Ref: D2014/52968

Springvale Mine Extension Project (SSD-5594)

SYDNEY CATCHMENT AUTHORITY DETAILED COMMENTS
for
SPRINGVALE MINE EXTENSION PROJECT
ENVIRONMENTAL IMPACT STATEMENT
June 2014

#014: Sawyers Swamp Creek below Springvale LDP009 (Salinity, mg/L)

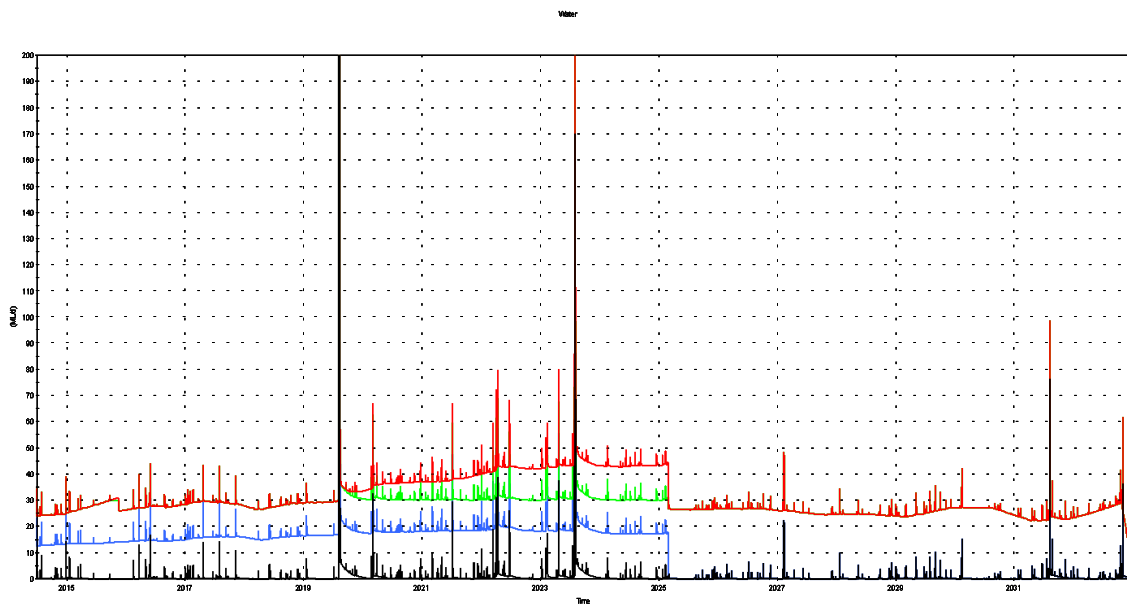
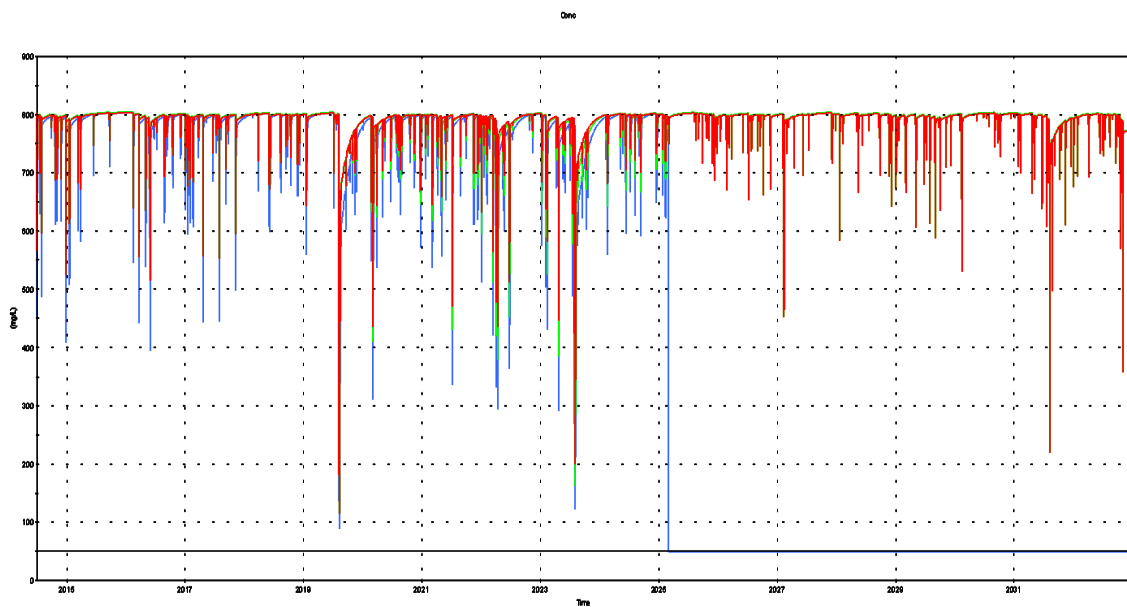
- Salinity predictions have been undertaken upstream of Lake Wallace, not where discharge occurs in Swayers Swamp Creek (LDP009). No predictions are made on what would be an expected increase in salinity compared to the current conditions at the discharge point LDP009 and impacts on water quality in Coxs River downstream of Lake Wallace. The model predictions for average Coxs River salinity should include an envelope around the average showing 10th and 90th percentiles.

#225: Coxs River immediately above Lake Burragorang (Salinity, mg/L)

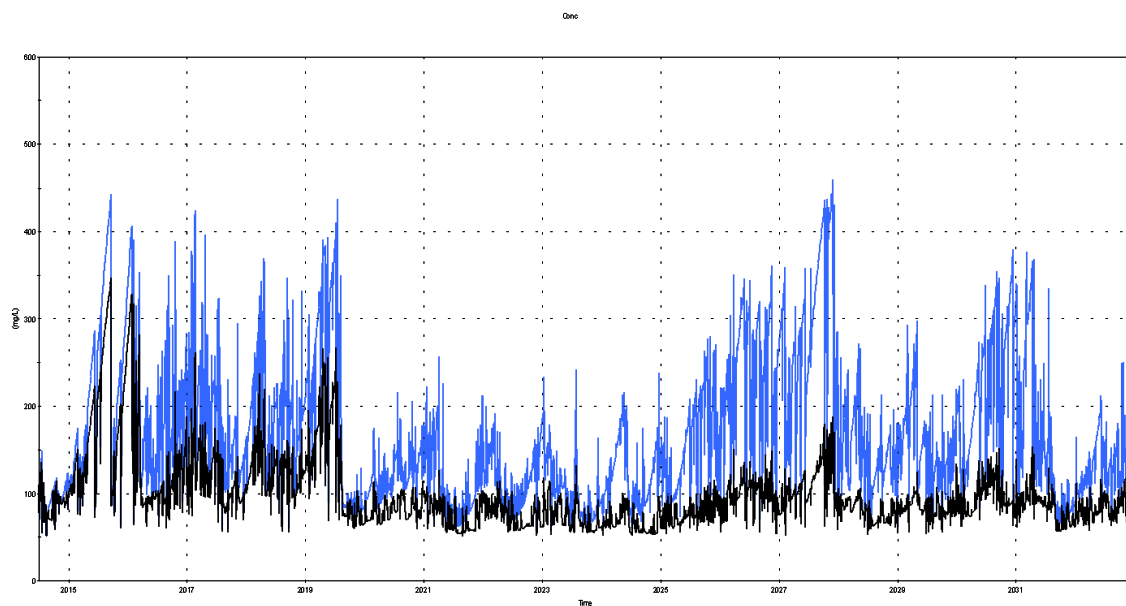
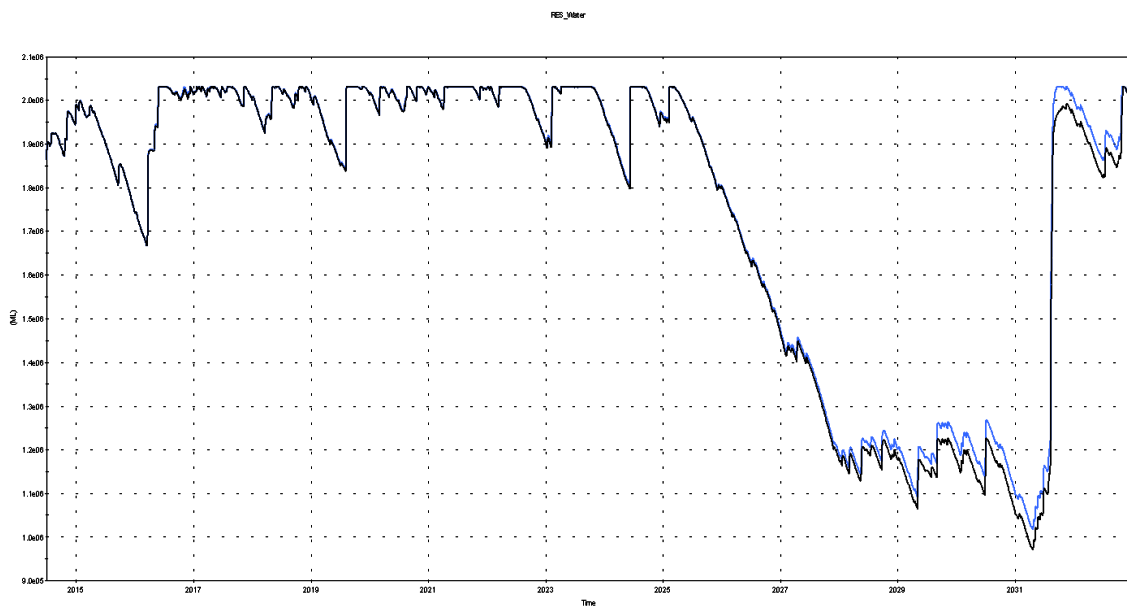
- There is no analysis whether elevated salt levels are likely in the Coxs River where it enters Lake Burragorang.
- The EIS states that based on the data available, estimated errors in predictions is approximately $\pm 30\%$. It is not clear if the upper limits would still fall within an acceptable level of impact.
